# CITY OF MERCER ISLAND

RE: Request for Information #2 for File No. SUB21-008 – Koneru Short Plat  
6610 East Mercer Way, Mercer Island, WA 98040; King County Tax Parcel # 302405-9153

KONERU SHORT PLAT (21-008)
6610 EAST MERCER WAY
MERCER ISLAND, WA 98040
PRELIMINARY SHORT PLAT

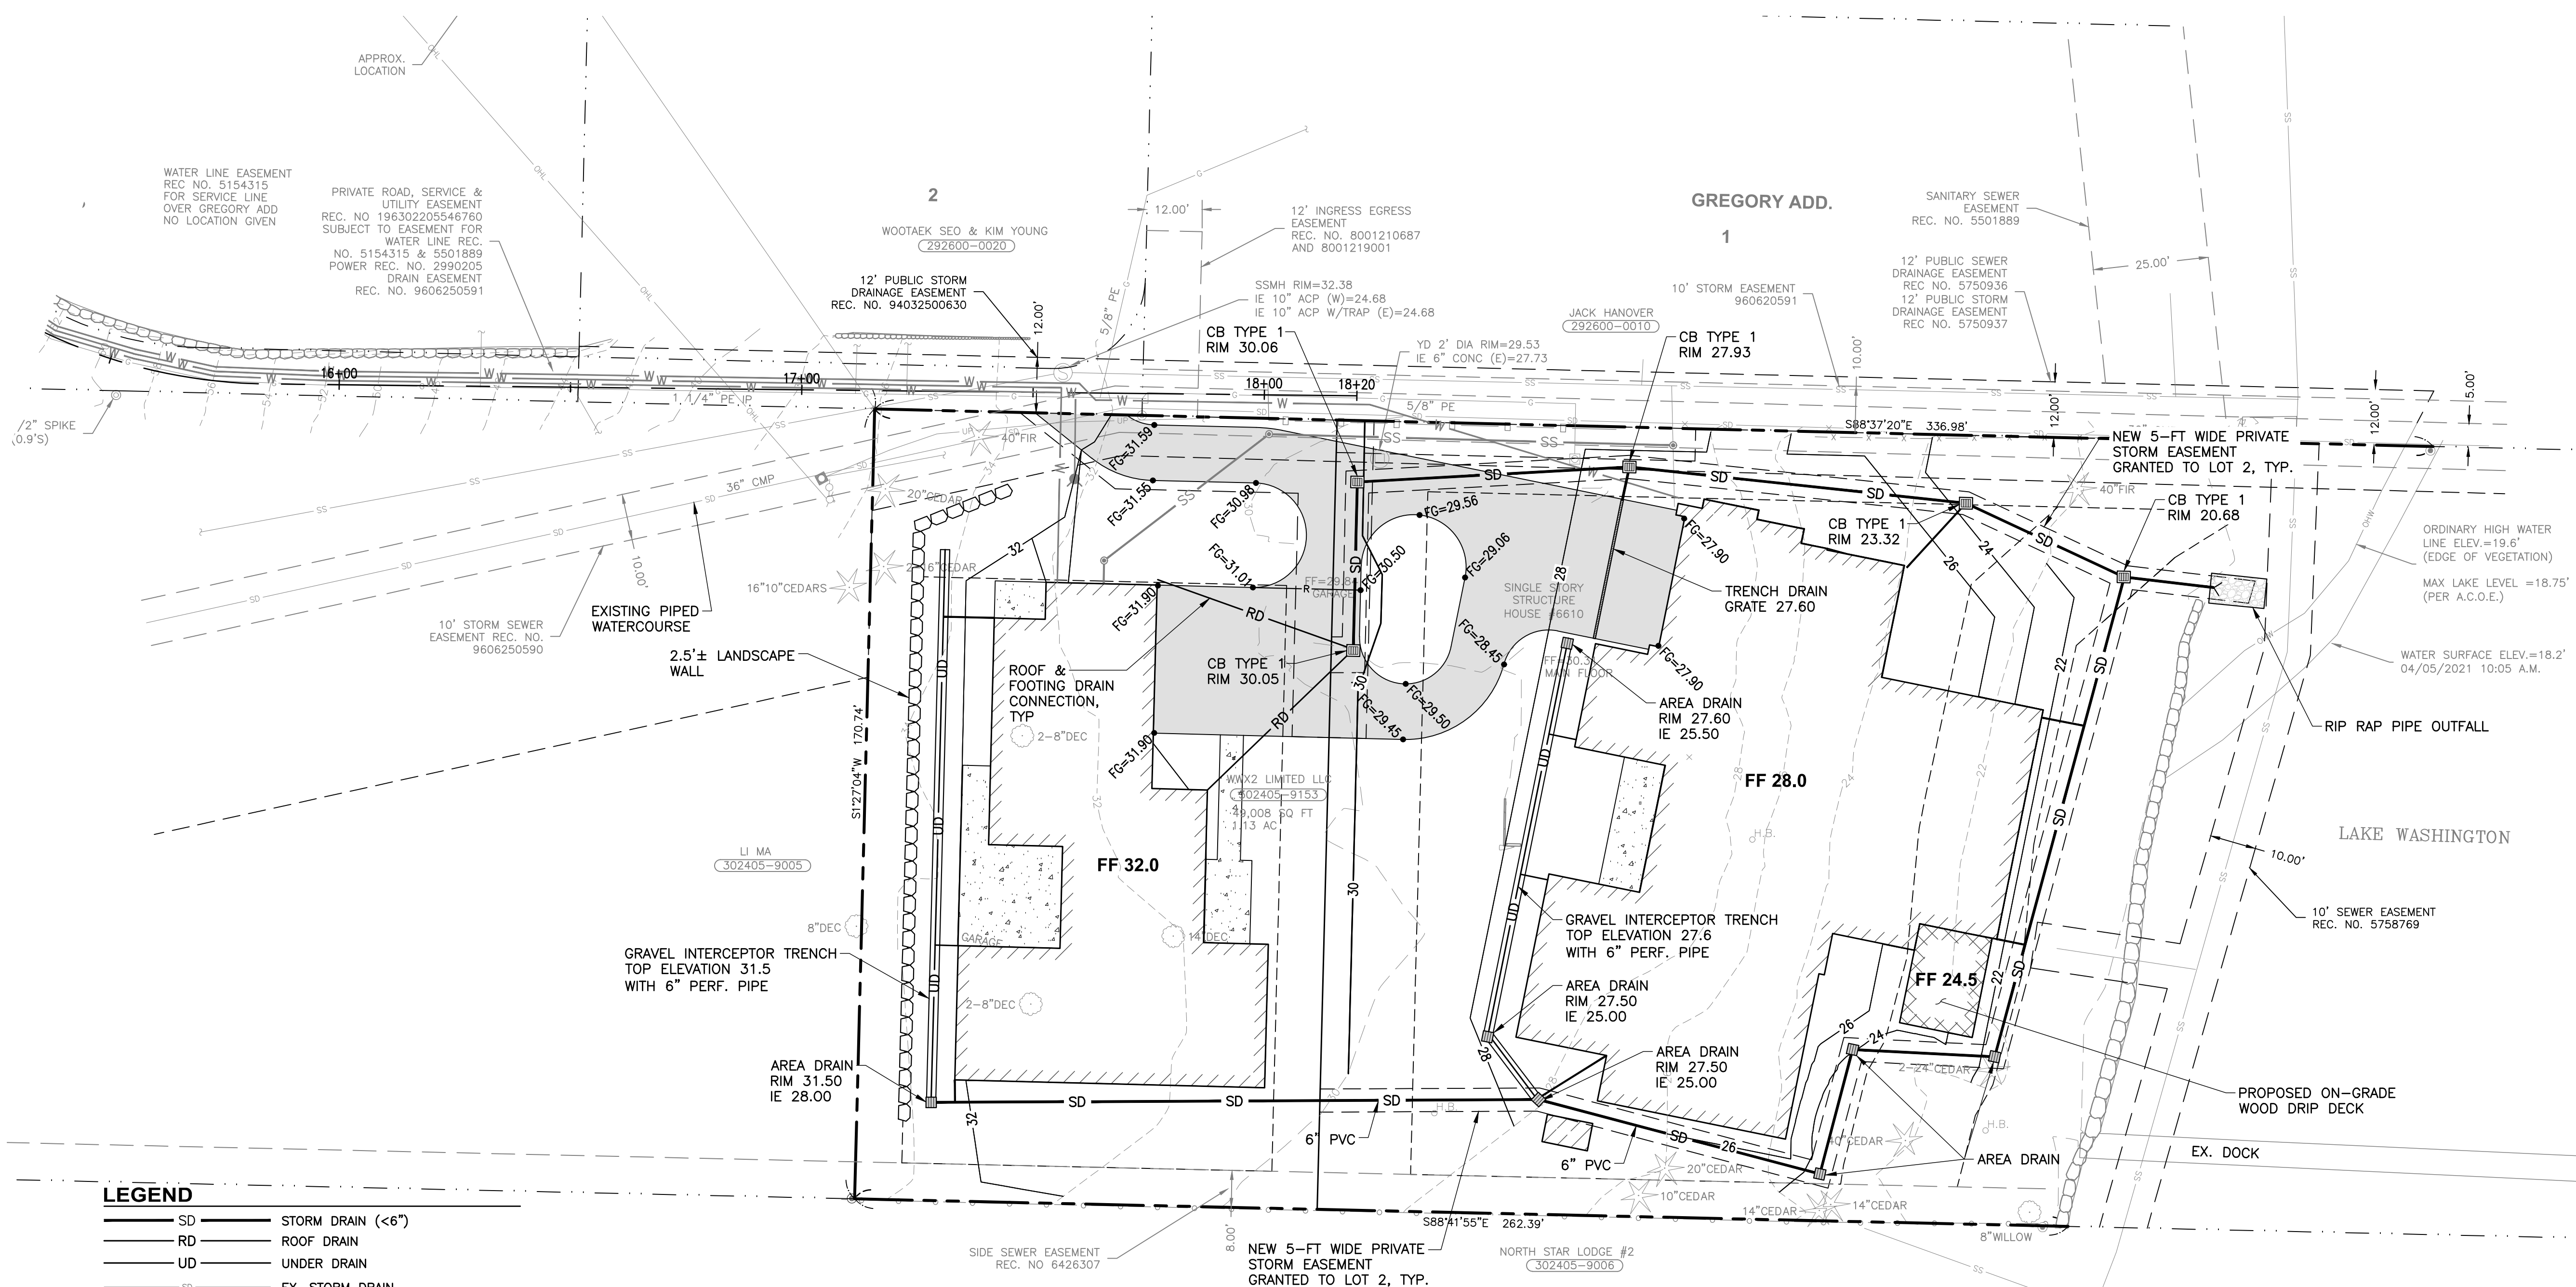
1. The plat map needs to have the statement from the fire marshals office placed on it.

***“All building permits are subject to meeting current fire code requirements at the time of a complete submittal, including fire apparatus access as outlined in adopted code sections of the International Fire Code Appendix D. Fire plan reviews will be conducted at time of building permit submittal and may require additional fire protection systems /or additional fire prevention measures for building approval.”***

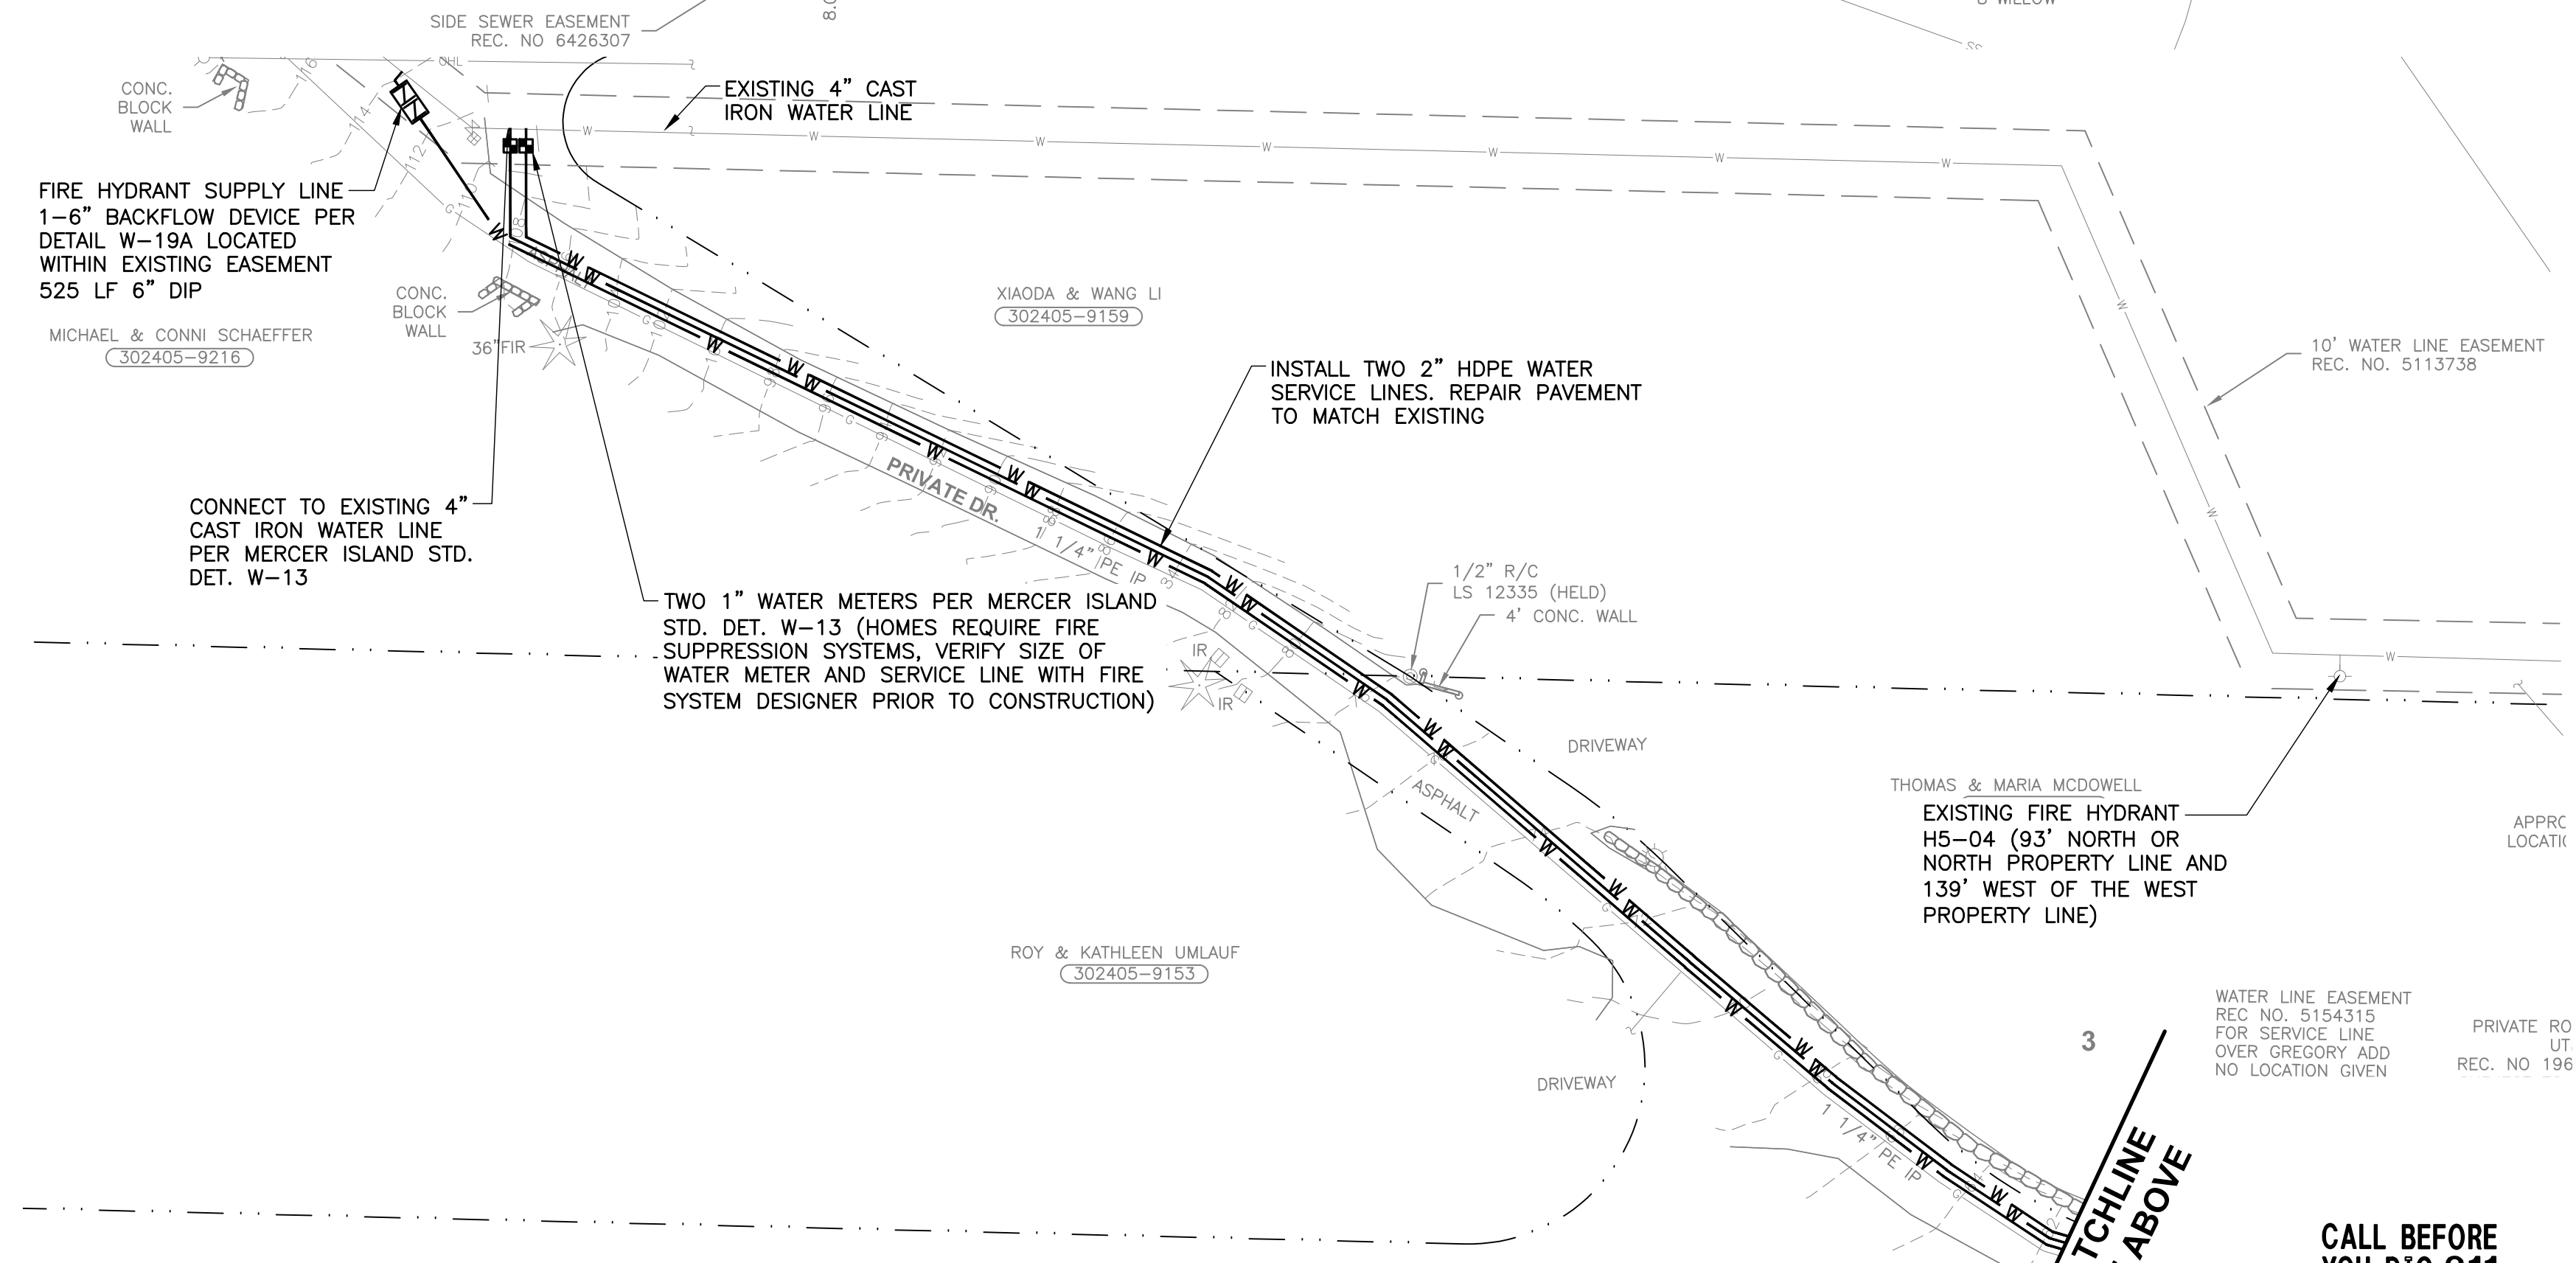
5. Future Building Permits:
  - a. For Civil and Arborist) During building plan review a tree protection plan with all Civil information must be created. Tree protection will need to be shown on C3.0. The retaining wall, trench, and other utilities to be moved outside saved trees driplines/minimum limits of allowable disturbance. The SD is shown within 9-feet of exceptional tree 576. Tree 575 also has a SD line within minimum limits of allowable disturbance. Update tree protection plan with tree protection chain link fence and all the following items in this checklist. Exceptional trees must be retained according to 19.10.060.3, and protected under 19.10.080.

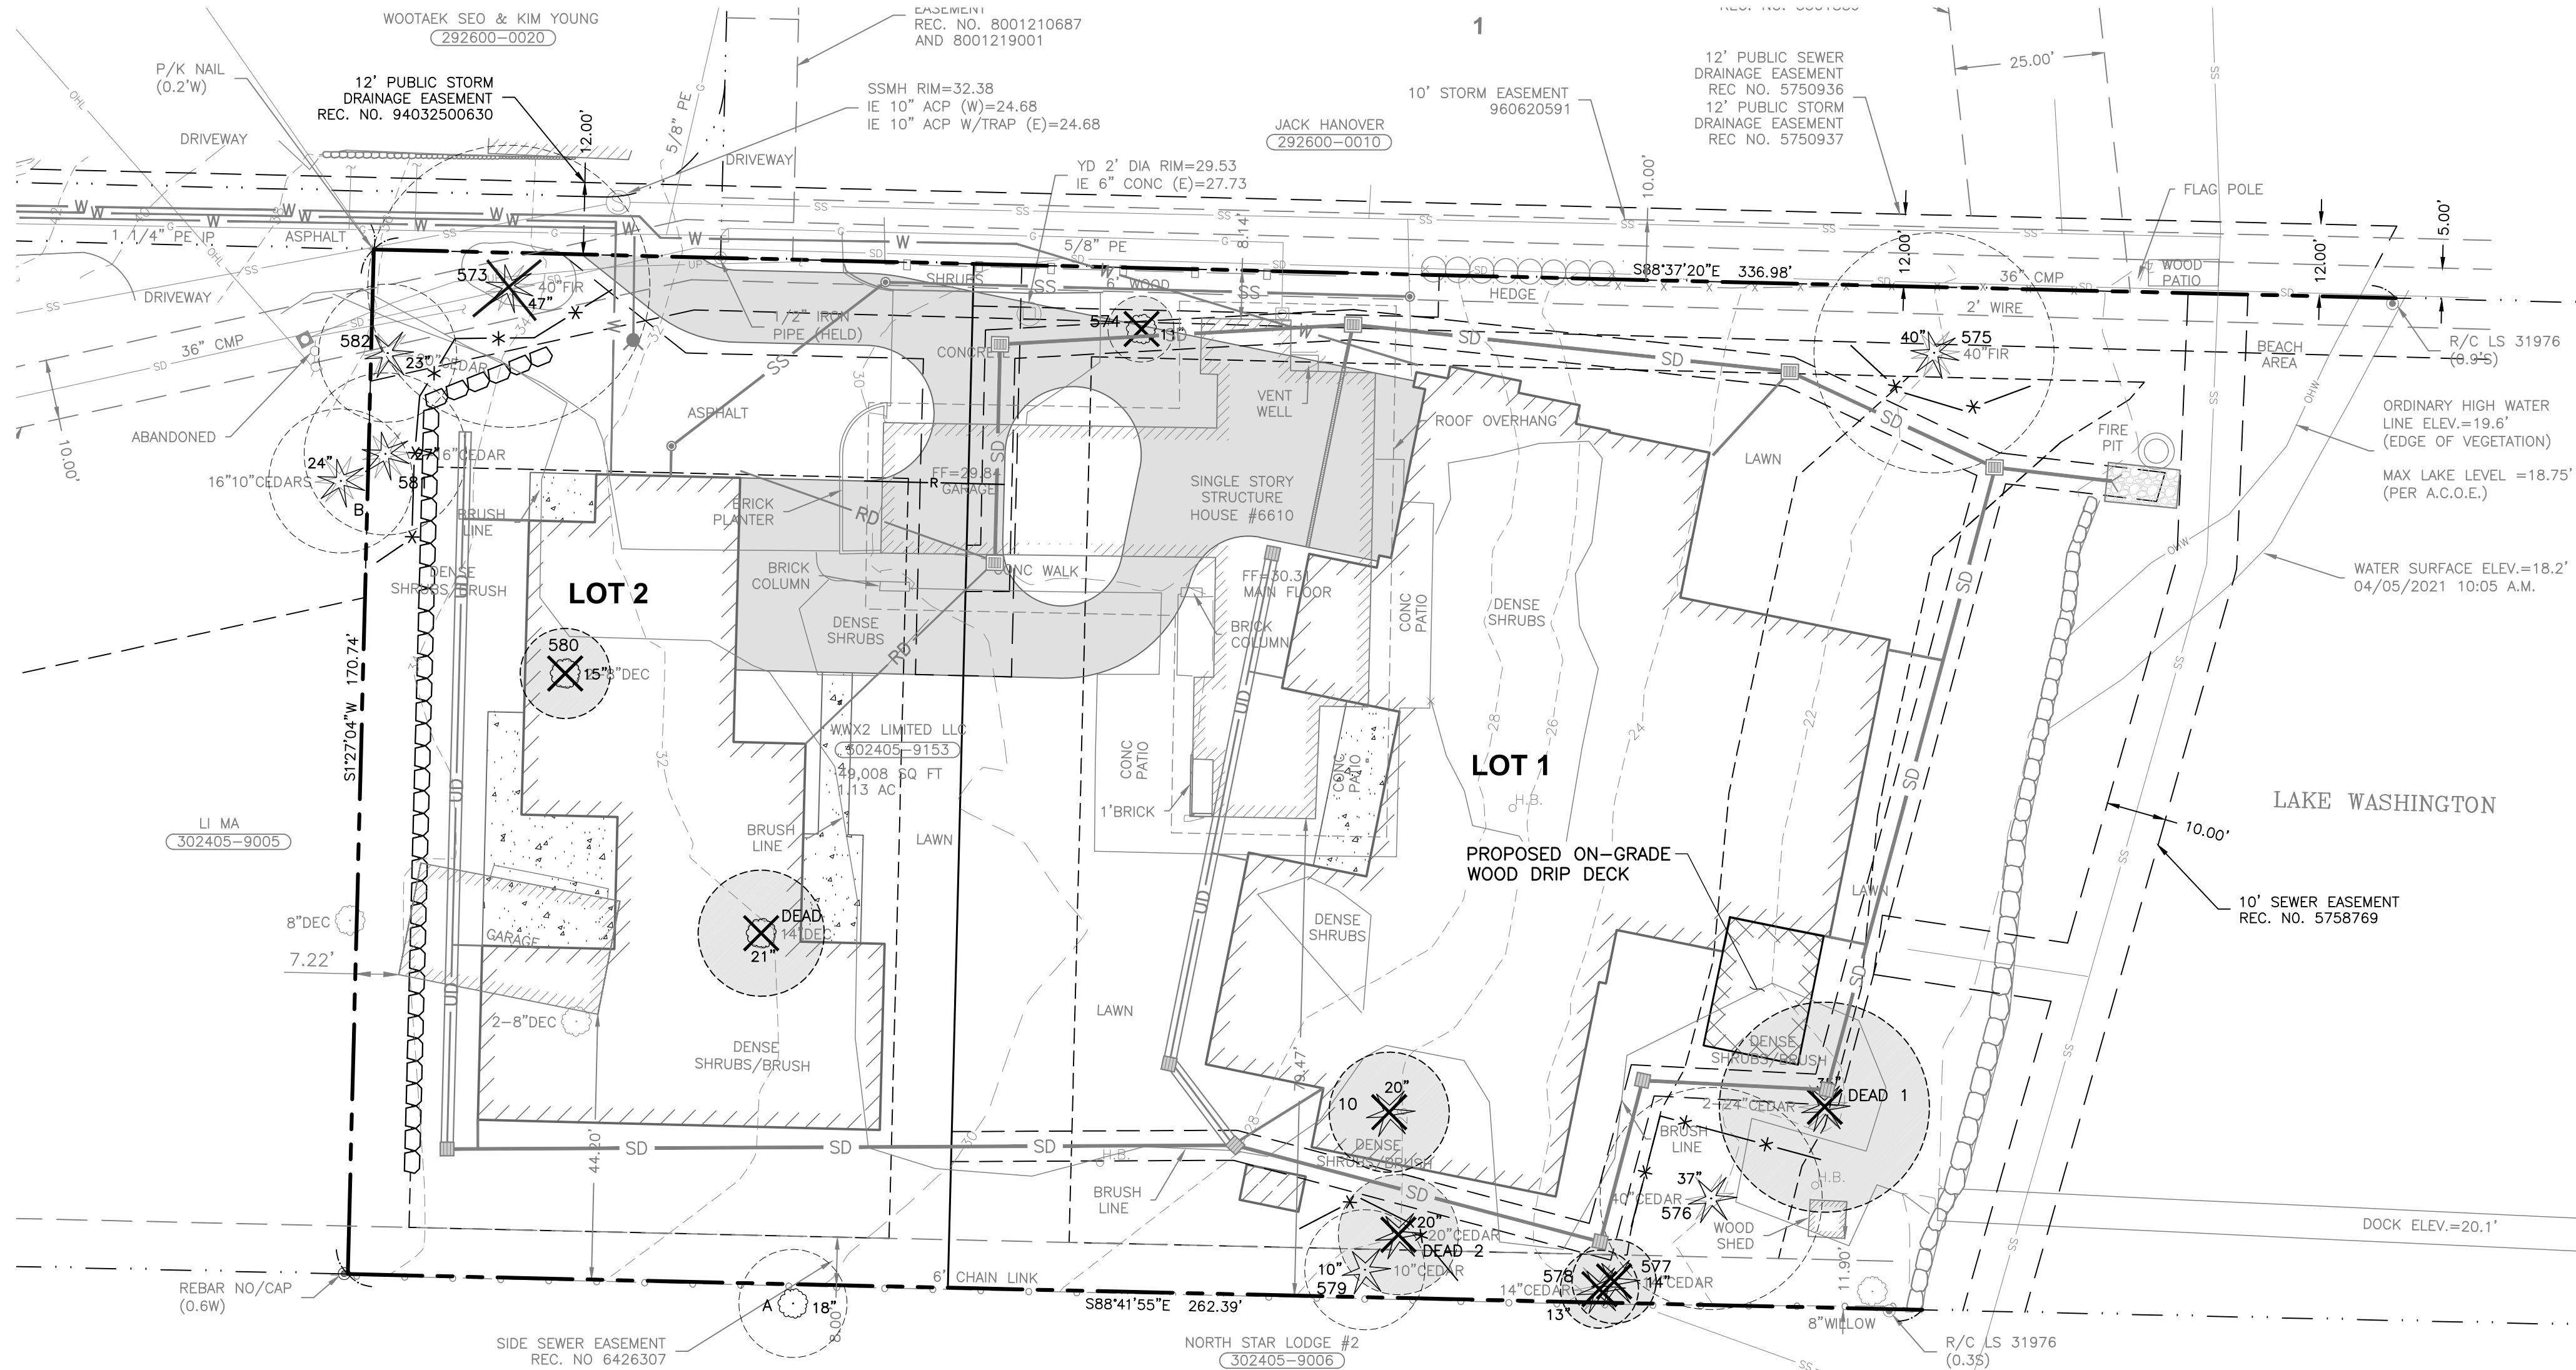
1. (Repeat comment for Architect/Arborist) provide Arborist evaluation that Dead Tree 1 would not have been damaged with the building pads encroachment into the tree's dripline. Even though this tree was already allowed for removal under a non-development tree permit. Since the tree was exceptional it would have been required to be retained and not damaged by development in the tree protection zone. This minimal excavation zone for the deck will be conditioned for the building phase.

2. (Repeat comment for Architect/Arborist) Provide the tree inventory worksheet and include all trees removed within five years. This will include the trees that were approved to be removed under the non-development tree permit before this development proposal. This was for five trees to be removed under permit 2104-048 (trees 6,7,8,10,15 in previous report). The tree protection plan must show at least 30 percent of trees being protected and not damaged by construction for this subdivision to be approved.

3. (Repeat comment for Arborist) Update Arborists tree report, a draft report has been submitted. Arborist will need to review new plans and confirm the distance of disturbance is adequate and will not damage the saved tree.

4. (New comment for Civil/Arborist) because of change of plans Tree 573 is exceptional in size and now shown for removal. Fire had approved Sub 1. What has changed? The new hydrant is beyond the minimum recommended limits of disturbance. Please provide the access and hydrant requirements that conflict with the tree. Could some asphalt removal mitigate for the impacts of the new improvements?
